Consultation Response from KC Waste Strategy(Refuse & Recycling)
2021/94552 Land at, Barnsley Road, Denby Dale, Huddersfield, HD8 8TS
Erection of 53 dwellings and associated works
Date Responded:
Responding Officer: Mike Hibbert
Responding Ref: WPN 21-025
NOTES/COMMENTS:

BARNESLEY ROAD : DENBY DALE | SITE LAYOUT

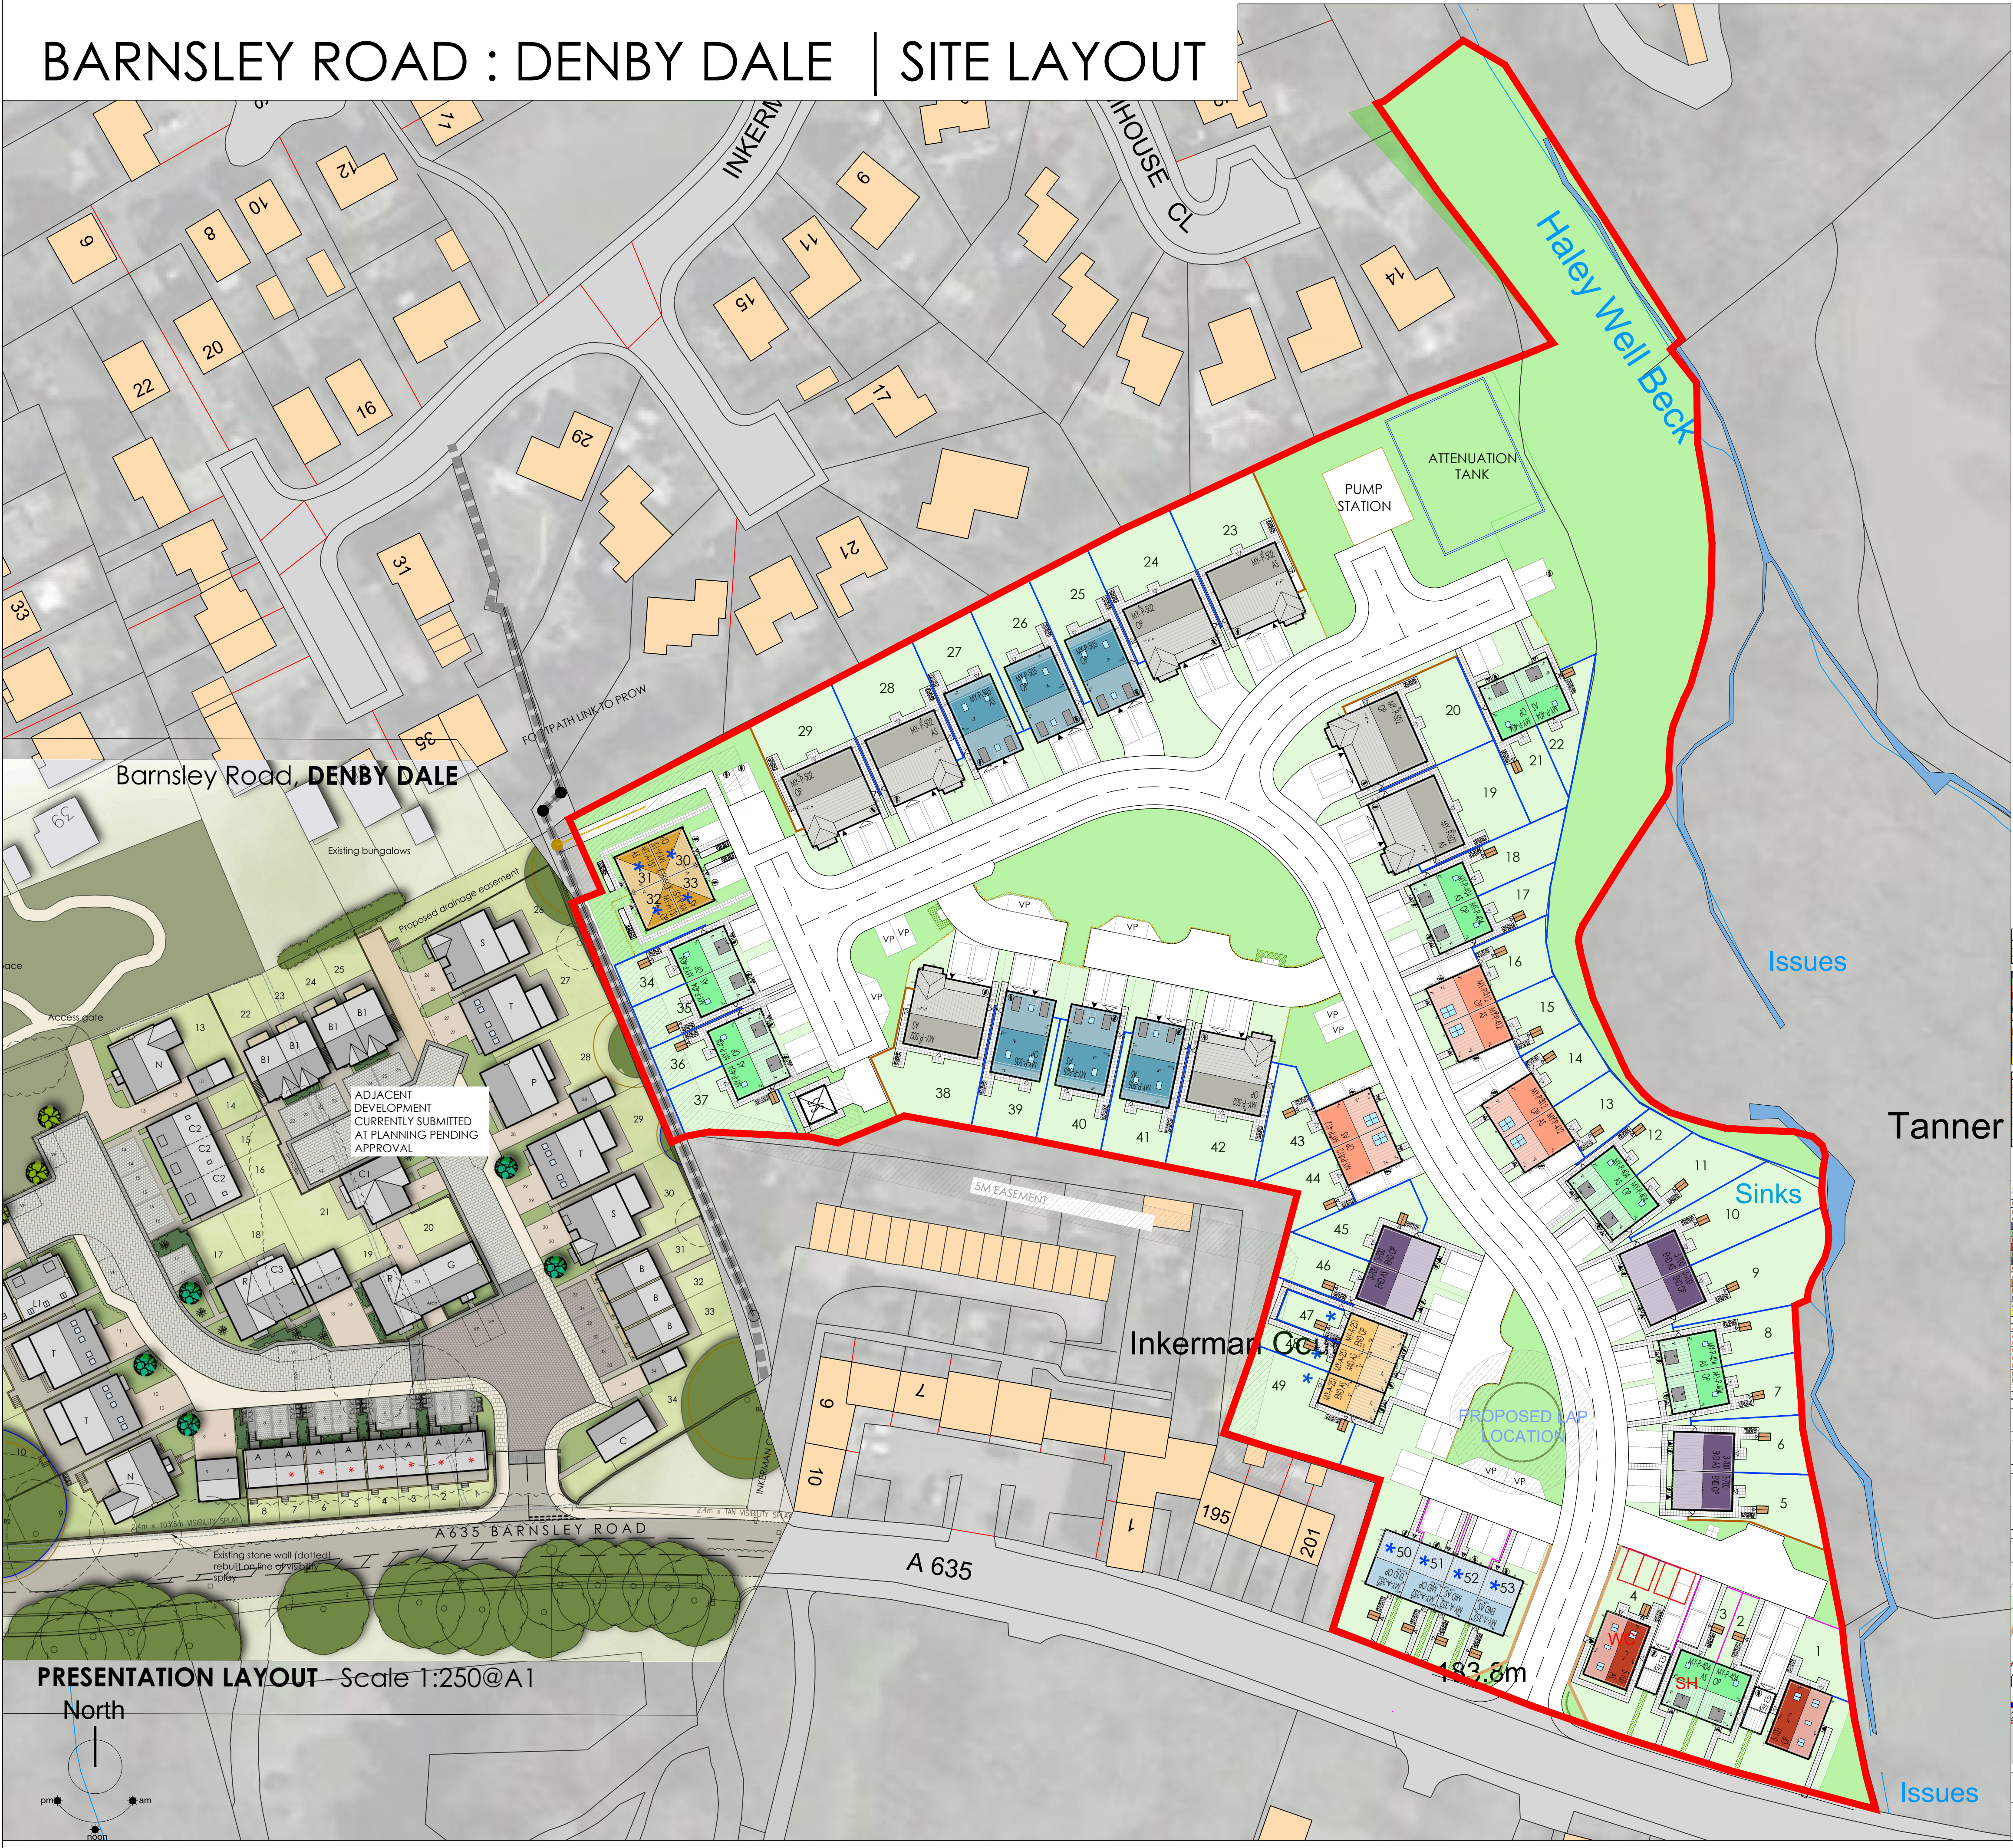
- Site Plan Ref 21-CL2-SEGD-BRDD-01 Rev :D dated 30/1/21 identifies the bin storage and presentation points within the development.
- Additional annotated is required to identify where bins from Plots 2 and 3 will be presented for collection.
- Plots 38 – 42 should have a presentation point identified
- Plot 48 has a convoluted bin drag around the rear garden of plot 47.
- Plots 45 – 49 should have a presentation point possibly opposite Plot 45
- It is not clear if Plots 50 – 53 will present bins on the pavement of Barnsley Road. A preferable presentation point would be adjacent to visitors parking bay opposite Plot 53

- Suitable site access and manoeuvrability space for a Refuse Collection Vehicle is vital to the Council's ability to discharge its obligation to collect waste from domestic properties. This obligation will exist in perpetuity on any residential development and as such will be a critical consideration in the layout of the site if outline/full approval is granted
- Parked cars are a perpetual problem for RCV access. This could be a particular issue in the turning point next to the pumping station opposite Plots 21 and 22. It is important to account for potential parking spaces in the swept path analysis.
